# Heckington Fen Solar Park

EN010123

## Applicant Response to the Examining Authority's First Written Questions

Document Reference: ExA.ResponseFWQ-D2.V1

DRAWING NUMBER: P20-2370\_107

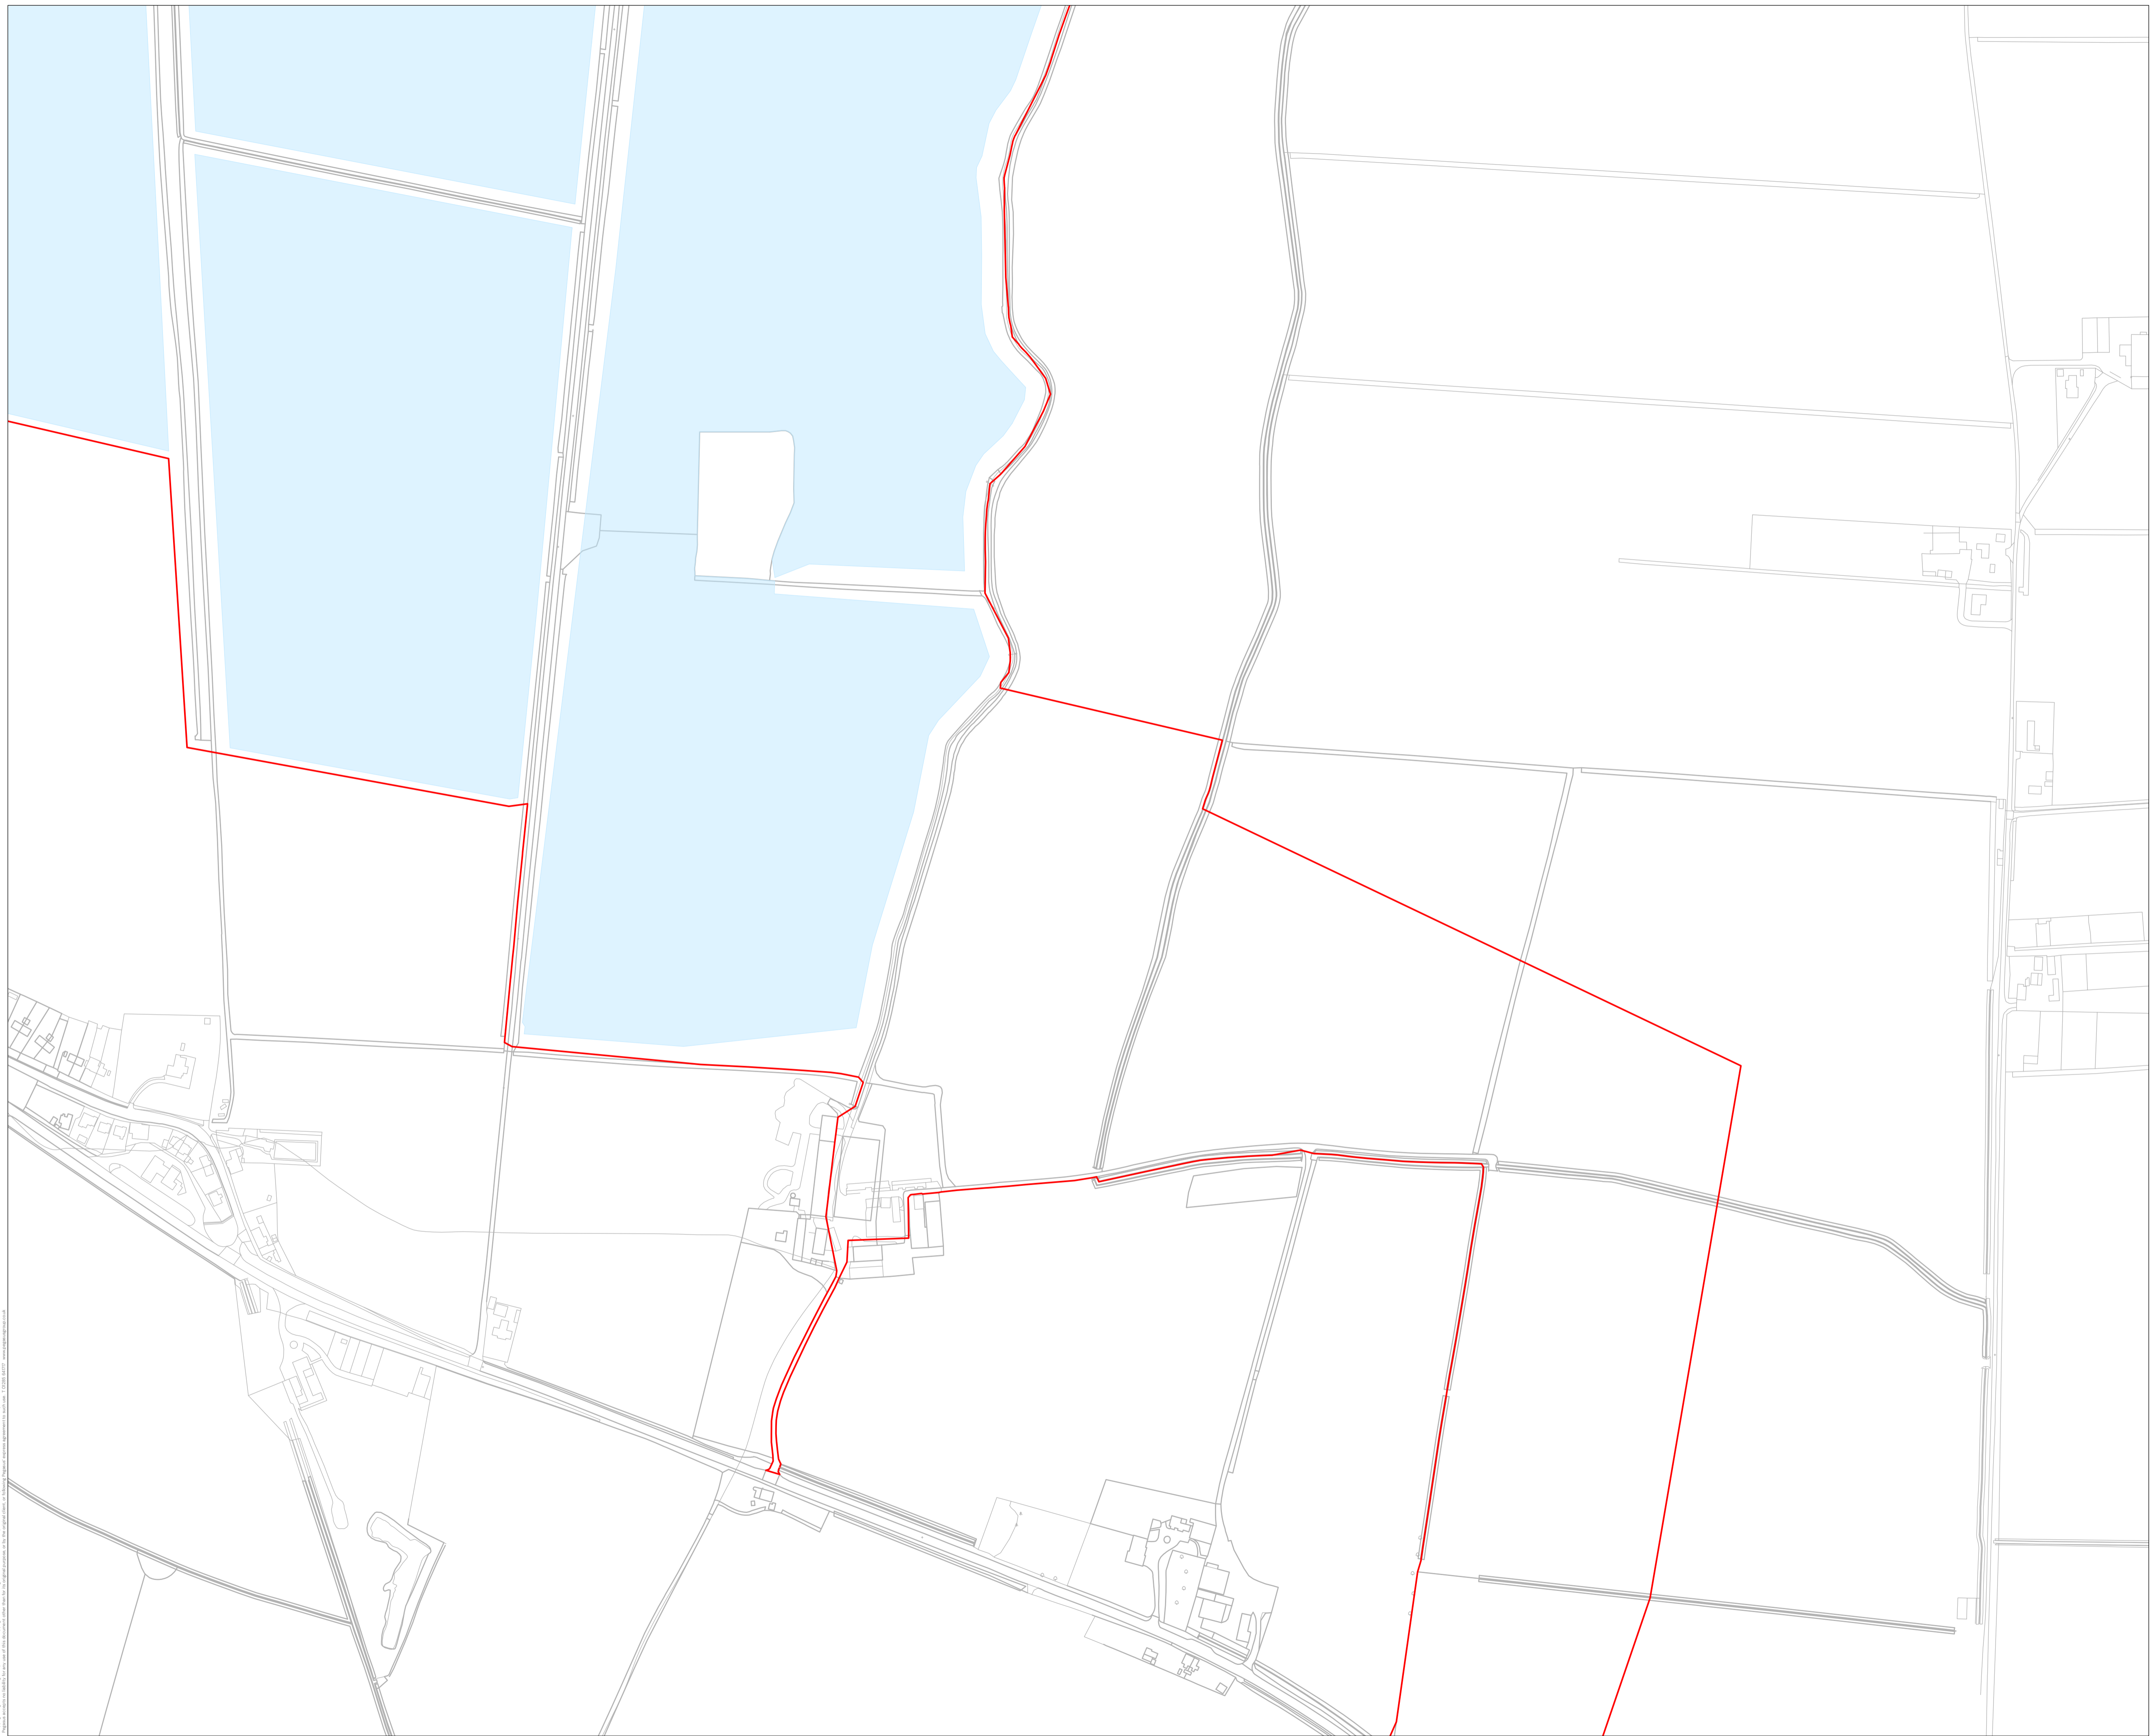
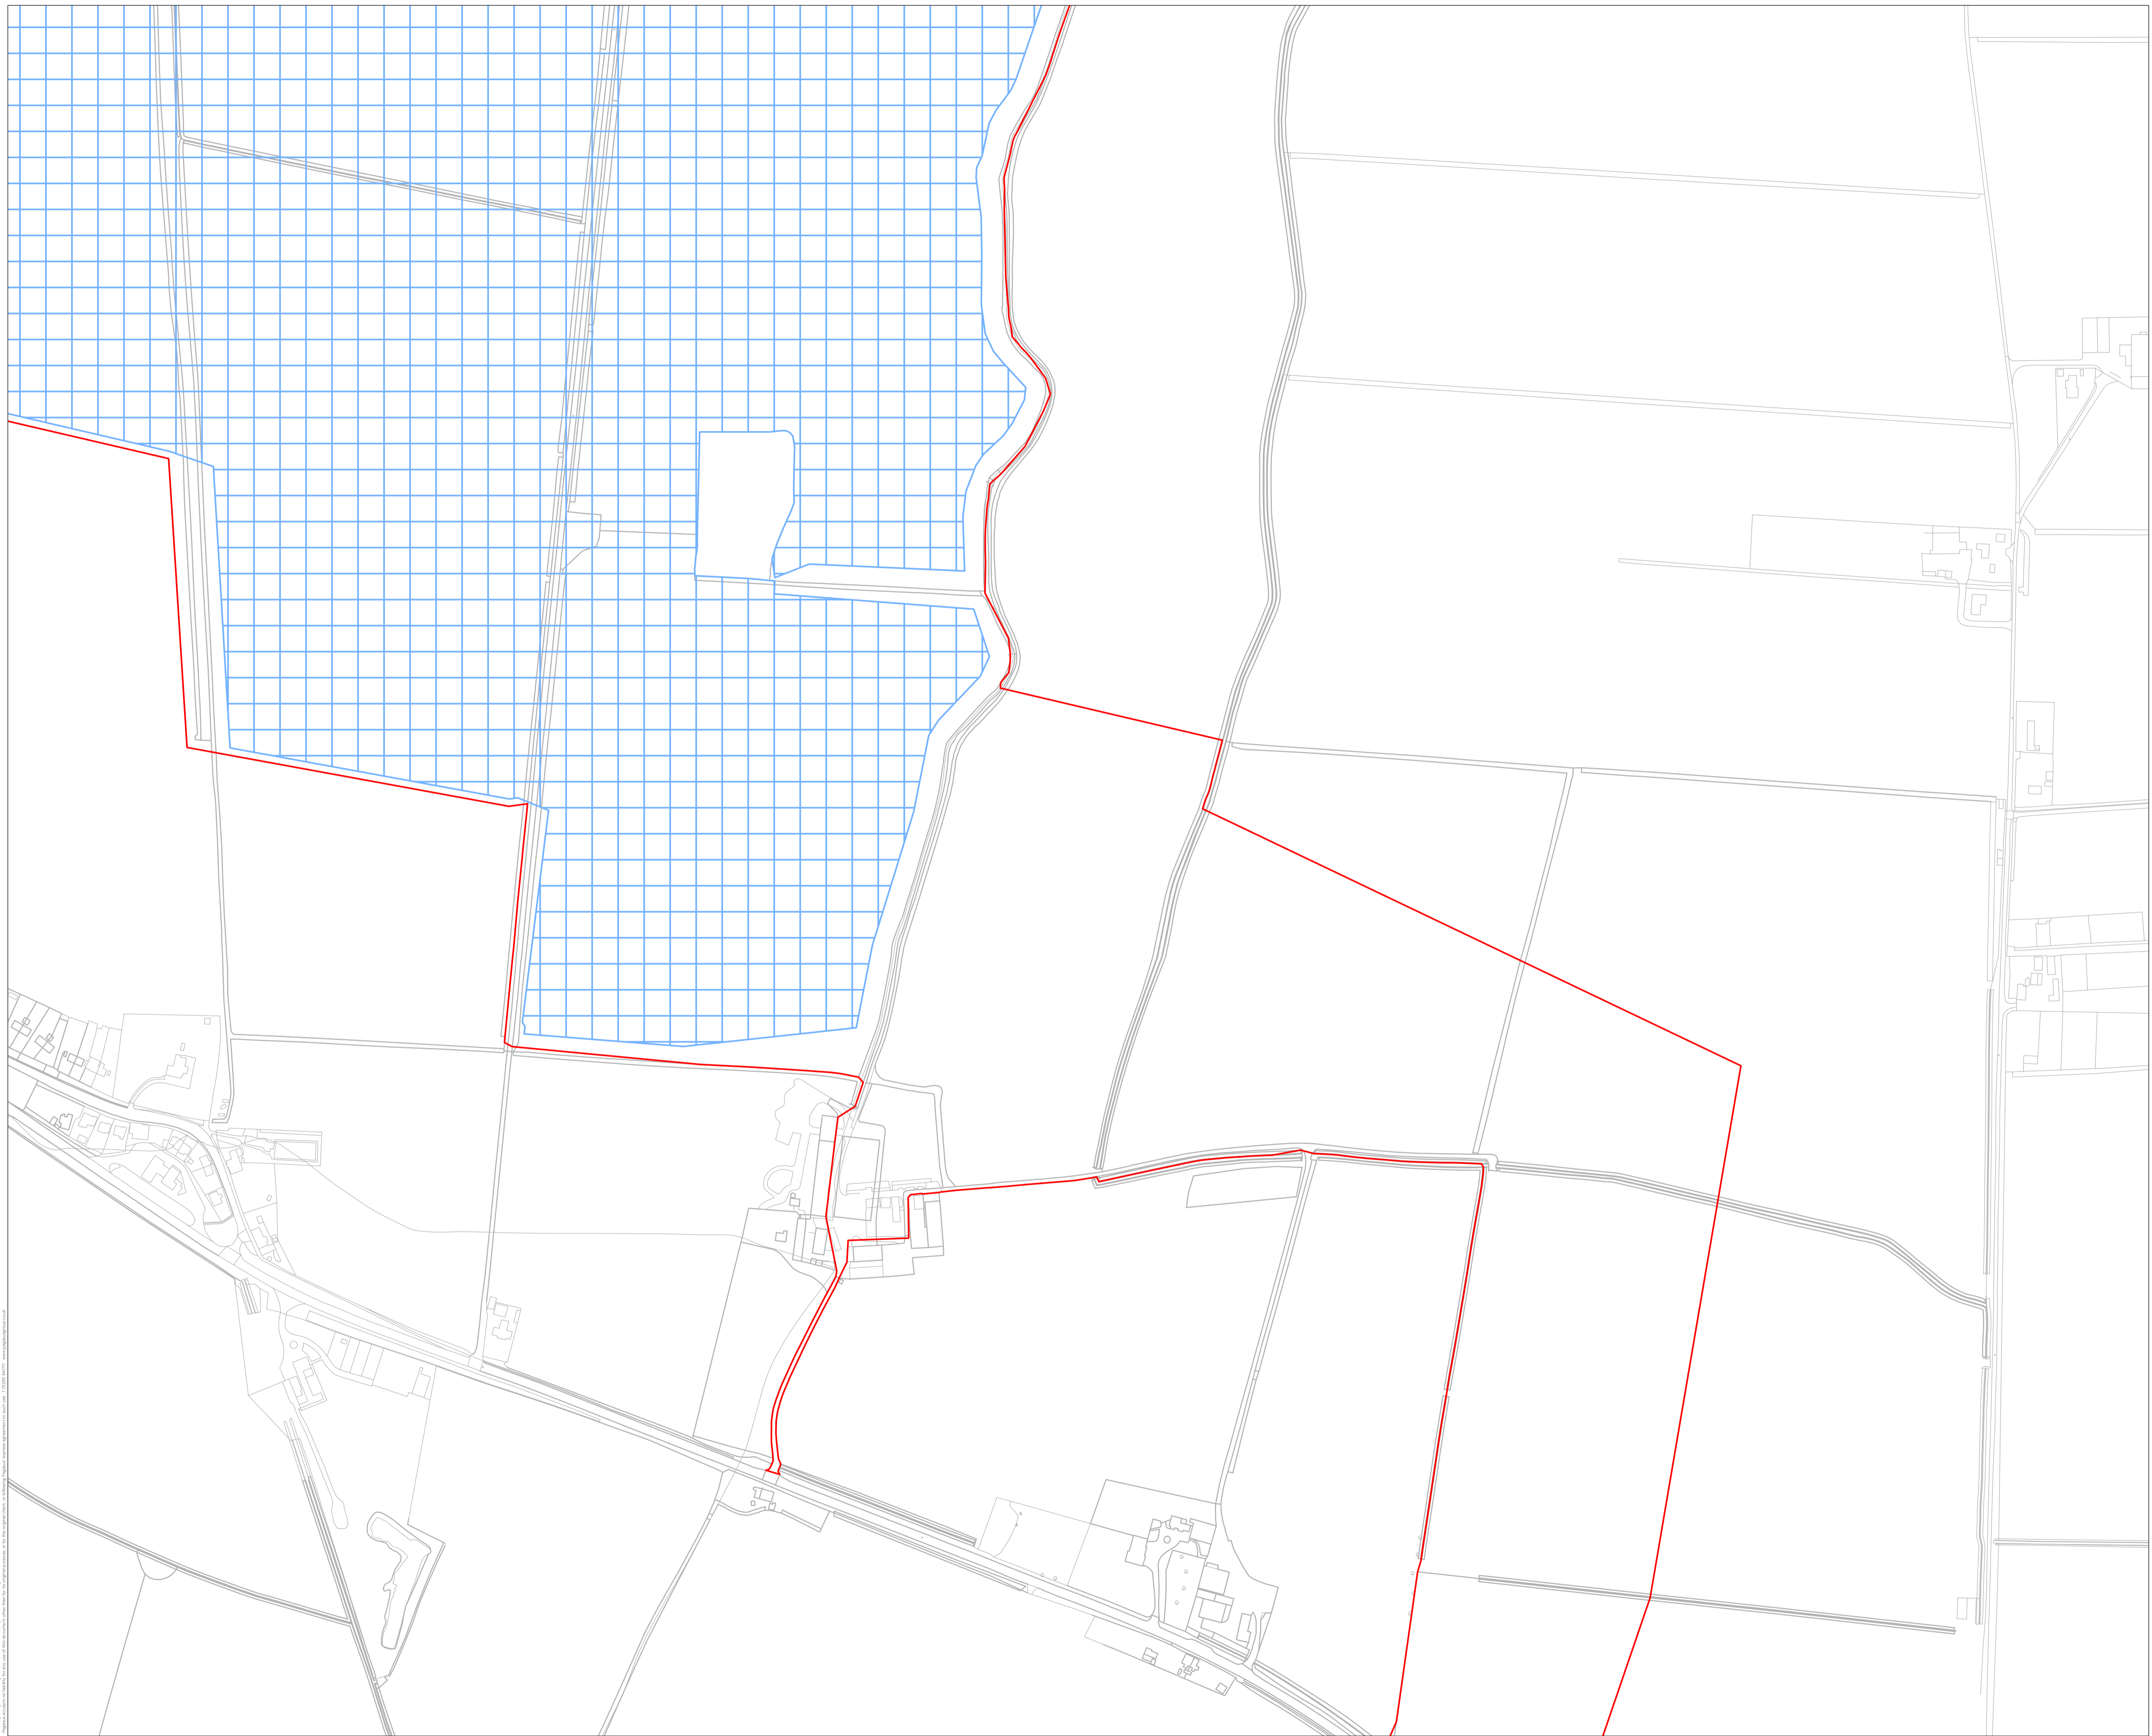
ExA Question Number:	Question Addressed to:	Question	Applicant's Response
GEN 1.1	The Applicant	<p>Sheets 5, 6, 12 and 13 of the Works Plans [PS-014] show numerous overlapping Works No's around the on-site substation and the Bicker Fen substation. Due to the scale of the plans and the overlapping colours/patterns the exact boundaries of many of the Work No's in these areas of the Proposed Development are ambiguous.</p> <p>Provide individual plans to clearly show the extent of each of the Work No's in these areas. These should not supersede the Works Plans but would be supplementary to them.</p>	<p>The Applicant has prepared a supplementary plan with individual sheets for each of the work layers shown on sheets 5, 6, 12, and 13 of the Works Plan. The Applicant has included this standalone document with the Deadline 2 submissions- <b>Supplementary Plan: Individual sheets showing isolated work areas for sheets 5, 6, 12, and 13 of the Works Plans</b> (document reference: ExA.SP-D2.V1).</p> <p>In respect of the <b>Works Plans</b> (document reference 2.2/PS-014), the Applicant has reviewed its approach to showing an illustrative layout of the substation and energy storage within the pink area on sheet 5 of the Works Plans. The Applicant previously considered that it may be helpful for stakeholders to see an indicative layout of how the infrastructure may be configured at the Energy Park. However, following further review (including alongside other DCO projects such as the recently consented Longfield Solar Farm Order), the Applicant has decided to remove the indicative infrastructure from sheet 5. This is because each numbered work must be situated within the corresponding numbered area shown on the works plan (pursuant to Article 3(2) of the DCO) and, as the Applicant outlines in paragraph 2.1.22 - 2.1.26 of the <b>Explanatory Memorandum</b> (document reference 3.3), the Applicant has adopted a Rochdale Envelope approach and assessed worst case parameters across this area. This means that the energy storage and onsite substation could be anywhere within this pink area on sheet 5. It could therefore be confusing or misleading to include an indicative layout at this stage of the process. Accordingly, the Applicant has removed this indicative infrastructure 'layering' from the Works Plans and updated accordingly in Revision 4 of the Works Plan submitted at Deadline 2. However, the indicative drawings remain, for reference, within the Environmental Statement at <b>Figure 4.1g- Indicative Energy Storage Arrangement</b> (document reference 6.2.4 / APP-108).</p>
